BOCA® NATIONAL BUILDING CODE/1999 PLAN REVIEW RECORD

Valuation: \$2,300,000
 Fee: \$2,221.00
 JURISDICTION: PORTLAND
 BUILDING LOCATION: 55 GRANV ST. (OVR 804)
 BUILDING DESCRIPTION: 2 - SUNNY BUILDINGS
 REVIEWED BY: [Signature]
 Plan Review # 090182
 Date: 3/17/04

A1.2

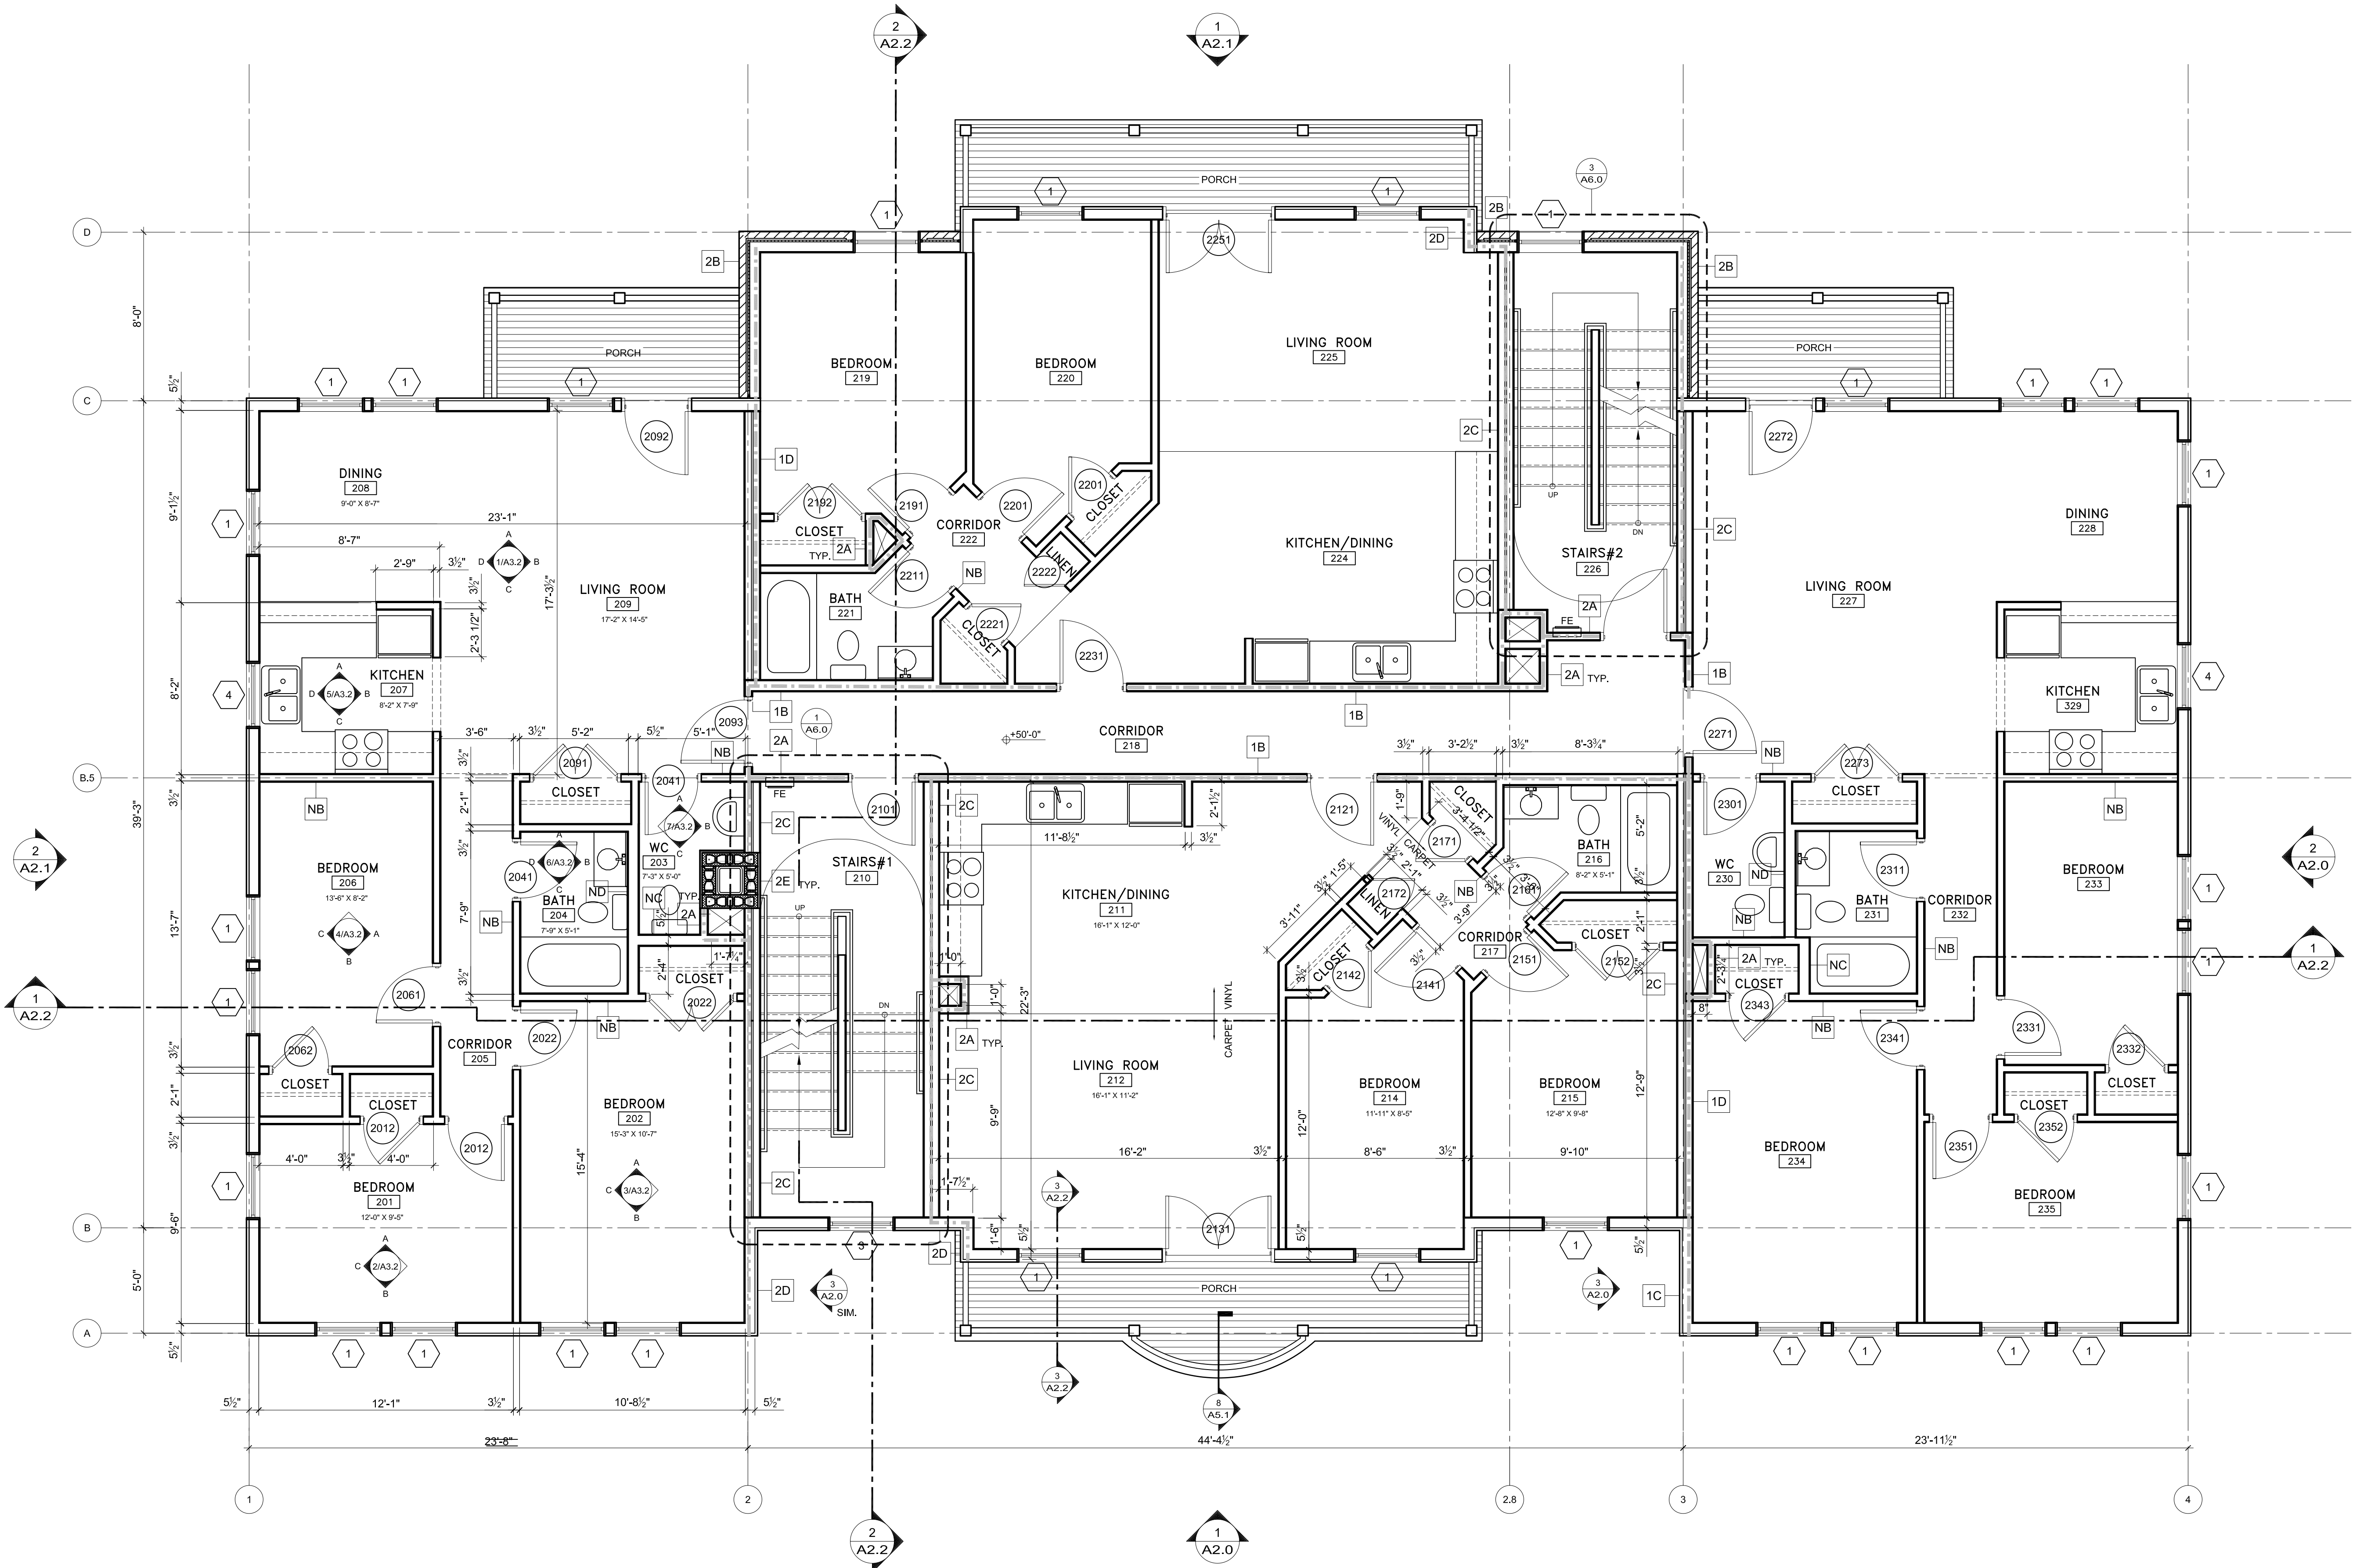
No.	DESCRIPTION	Code Section
205.2	REAR WALL BUILDING B - SEPARATION	205.2
A1.2	STCS IN HALLS ASSEMBLY 39 NOT 45	1214.2
A1.2	ALBERT STREET HALL - SHOWN BY 2000 CODE	
A1.2	USE ONLY LA NEPA IS SYSTEM	313.12
A1.2	EXIT ACCESS CORRIDORS ARE SHOWN IN PLANS - 1 Hr IN CODEBOOK 1/3 HP?	
	SPACE w/ 2 Hr PROTECTION	
	REAR WALL BUILDING B - SEPARATION	
	EXHAUST SYSTEMS FOR BARRIERS PENETRATIONS	
	FLOOR CEILING ASSEMBLY - DAMPERS
